**WEST SUSSEX COUNTY COUNCIL
FLOOD RISK MANAGEMENT CONSULTATION**

PLANNING REFERENCE: AL/115/17/OUT

LOCATION: Wings Nursery, Lidsey Road, Aldingbourne, PO20 3SU

Drawing Title
Drainage Strategy

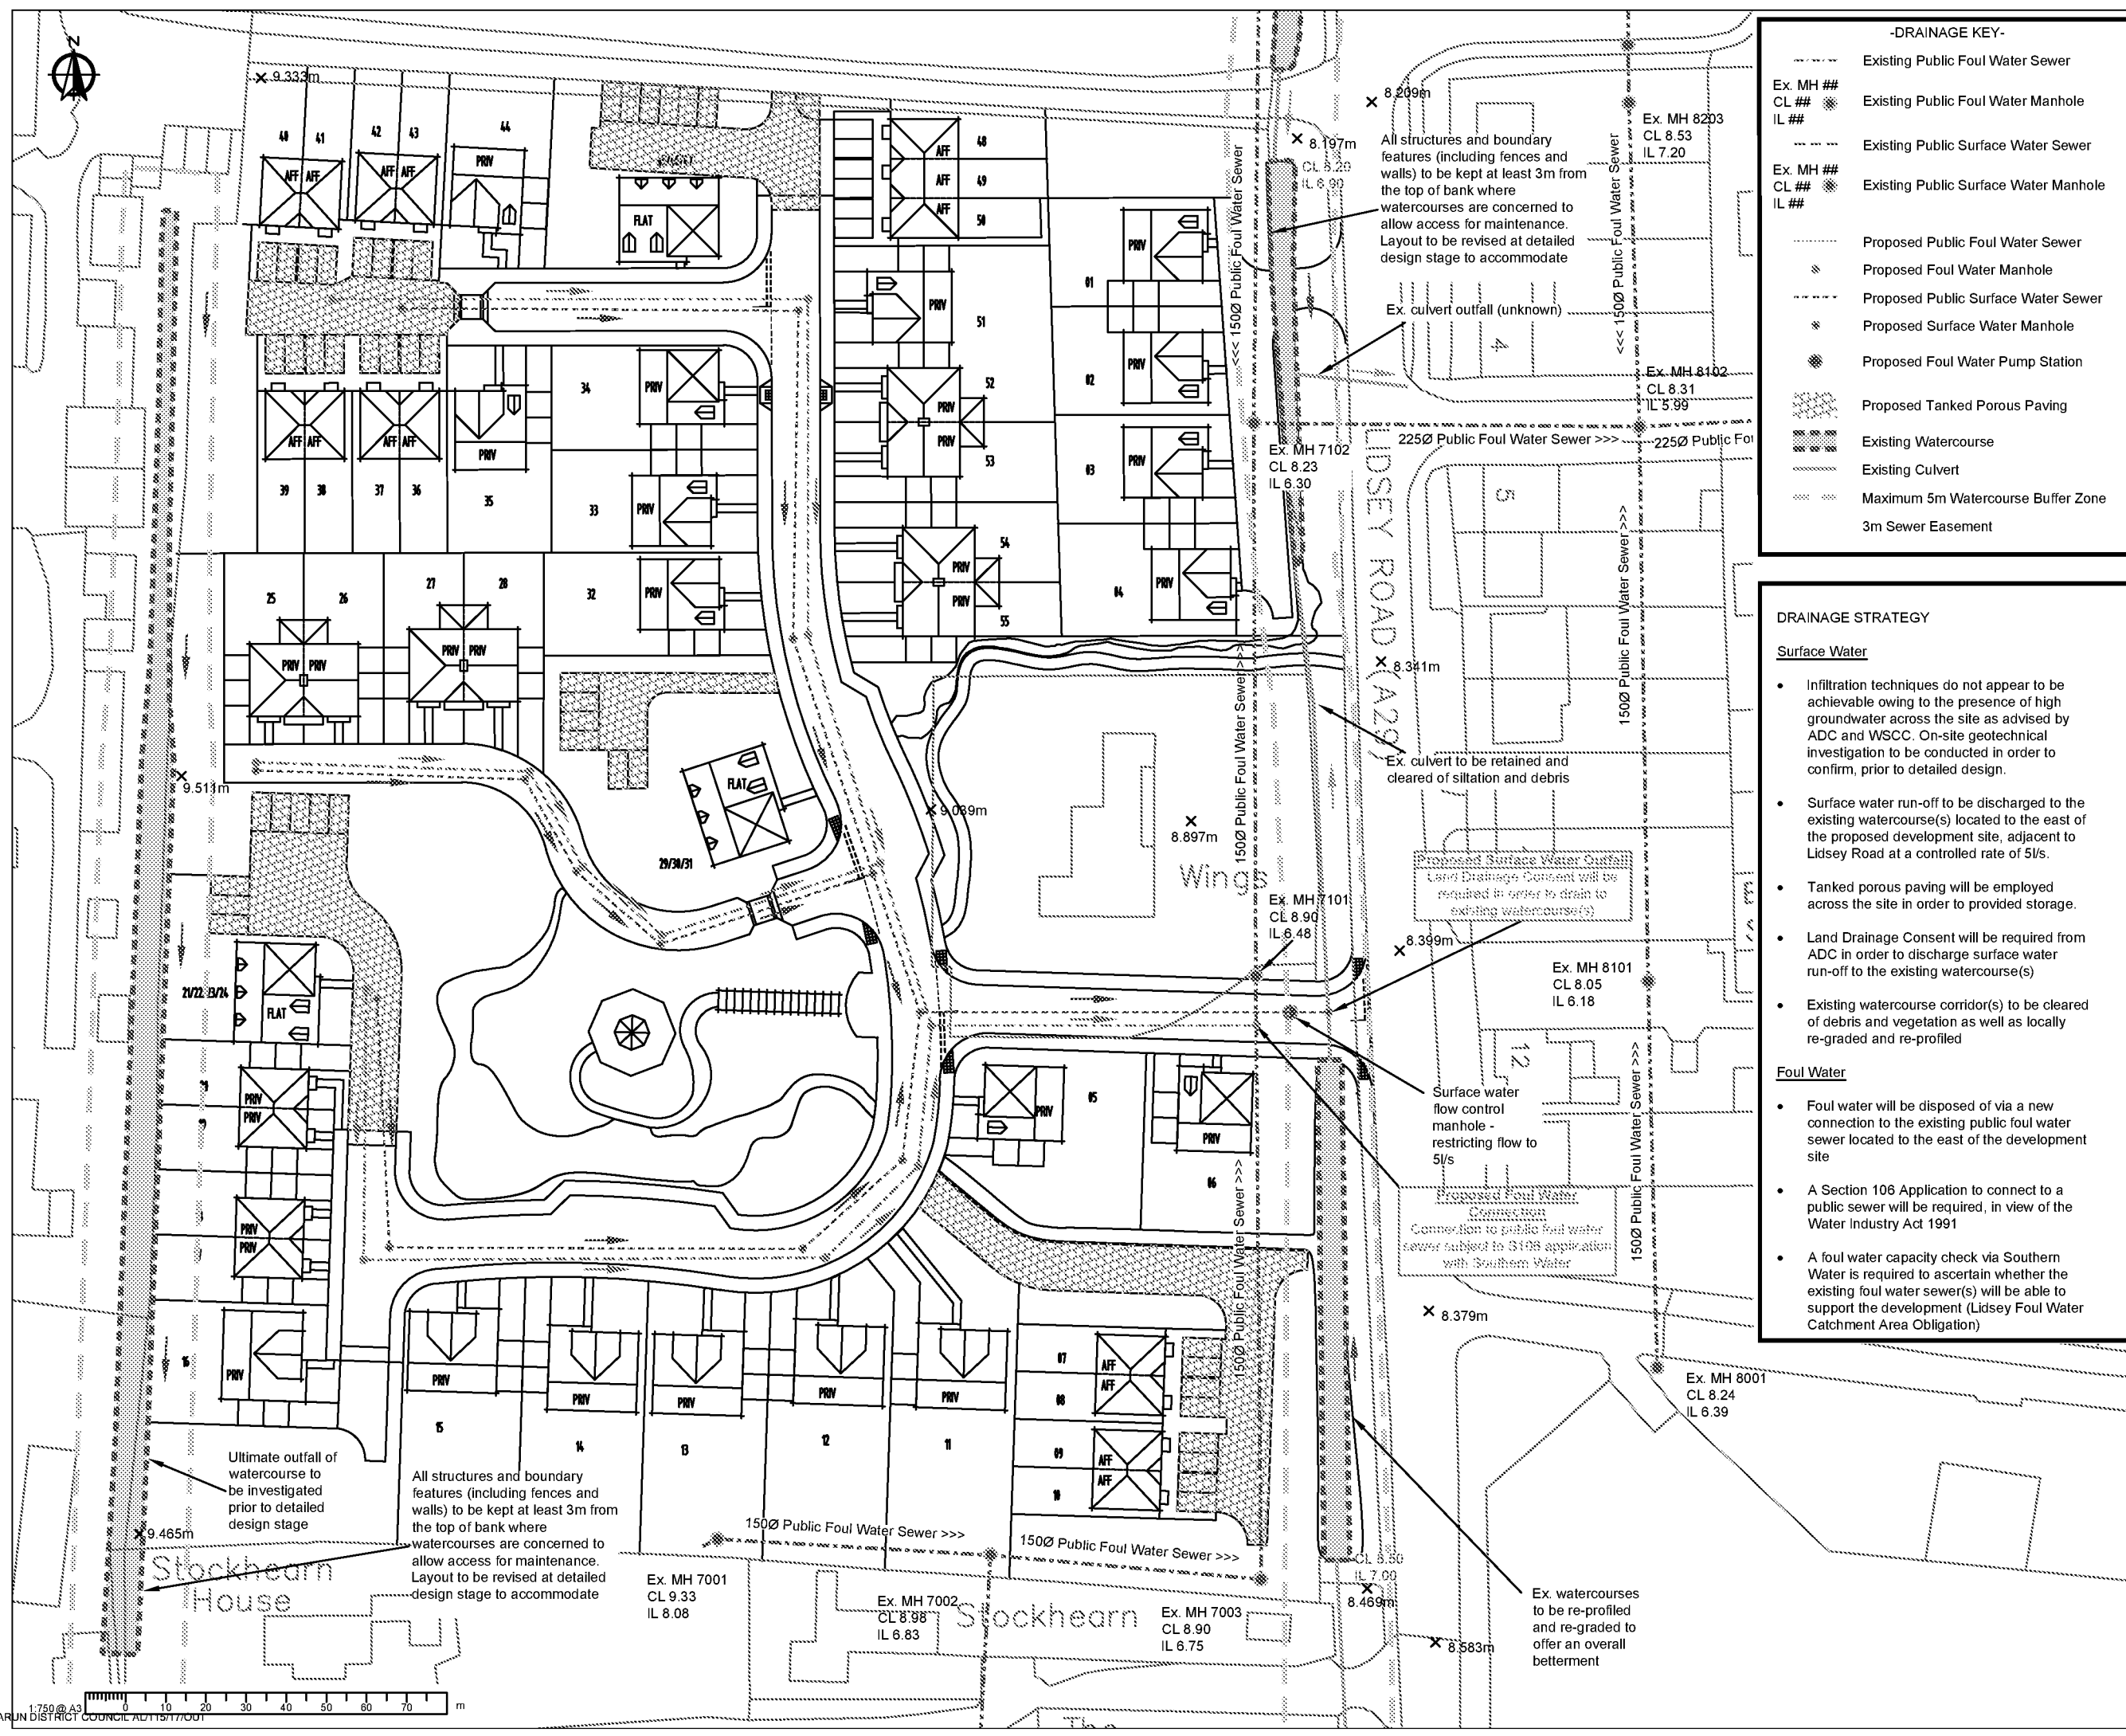
The 'Sustainable Drainage' section of the Design and Access Statement included with this application proposes that permeable paving, swales, French drains and infiltration basin would be used to control the surface water runoff from the site. In line with the SuDS selection hierarchy, infiltration testing/groundwater monitoring should be carried out for the entire site to assess whether infiltration is possible.

Development should not commence until finalised detailed surface water drainage designs and calculations for the site, based on sustainable drainage principles, for the development have been submitted to and approved in writing by the Local Planning Authority. The drainage designs should demonstrate that the surface water runoff generated up to and including the 100 year, plus climate change, critical storm will not exceed the run-off from the current site following the corresponding rainfall event.
